File No: SF19/84906  
Ref No: DOC19/667220

**RE: UON Honeysuckle City Campus Revised Concept Plan (SSD 9262)**

**Cheryl Brown**  
Manager, Northern Region  
Heritage, Community Engagement  
Department of Premier and Cabinet  
**As Delegate of the NSW Heritage Council**  
**29 August 2019**

Figure 7 SHR Curtilage and Concept Plan

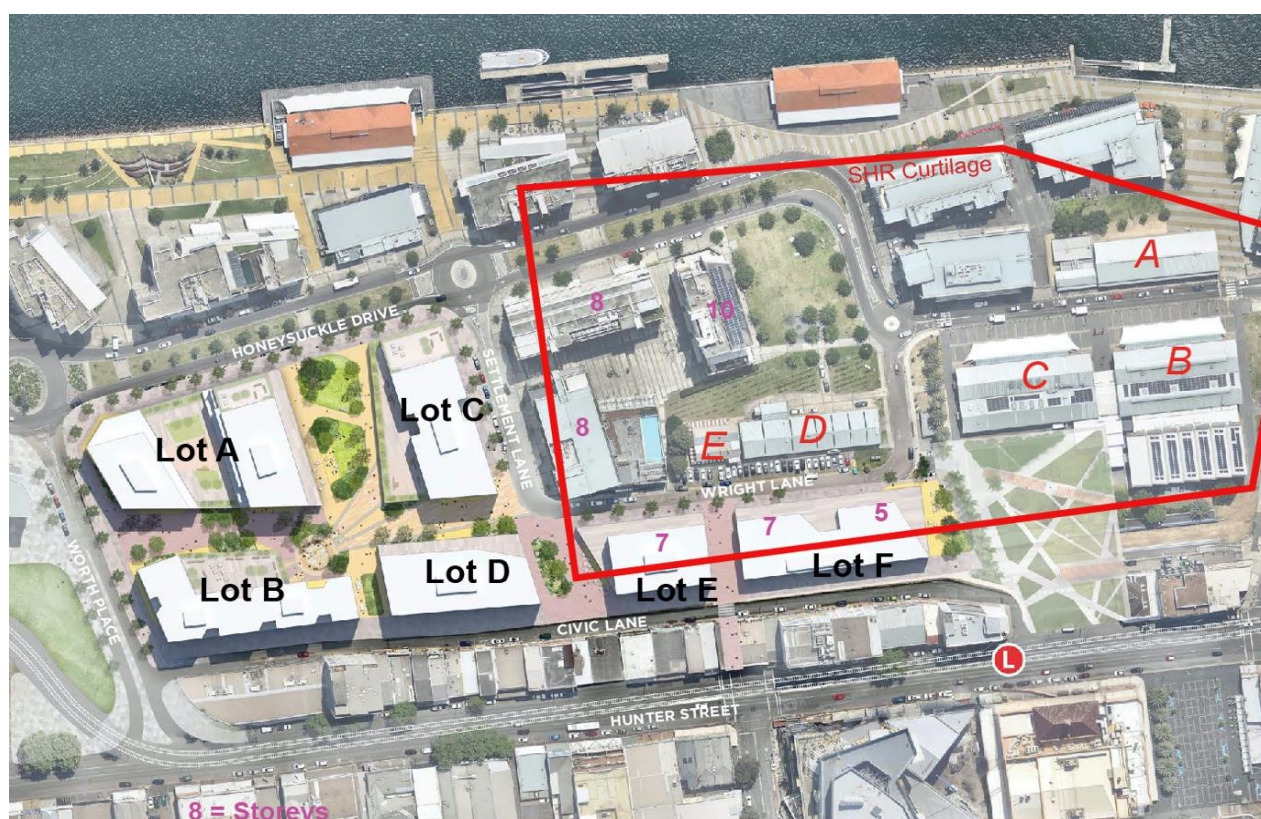
It is noted that the amended concept plan proposes a maximum seven storey building envelope within the curtilage of the Civic Railway Workshops. Whilst the Heritage Council's recommended conditions relating to archaeology and external finishing and materiality of the proposed development have been noted by the applicant, concerns regarding the adverse impact of the proposed development due to its intrusion into the SHR curtilage of the 'Civic Railway Workshops' remain unaddressed.

The 'Civic Railway Workshops' is significant as one of the 'outstanding industrial workshop sites in the State' and proposed development within the curtilage of the heritage item will have adverse heritage impact on the setting and character of the heritage item and on the views, as advised earlier. Therefore, the recommendation previously provided and listed below, remains valid and needs to be addressed before the proposal has irreversible damage to the setting of this State Heritage listed item:

1. *It is recommended that the concept plan be revised to remove the proposed intrusion into the SHR curtilage to avoid the visual impact and impact on the setting of the Civic Railway Workshops.*
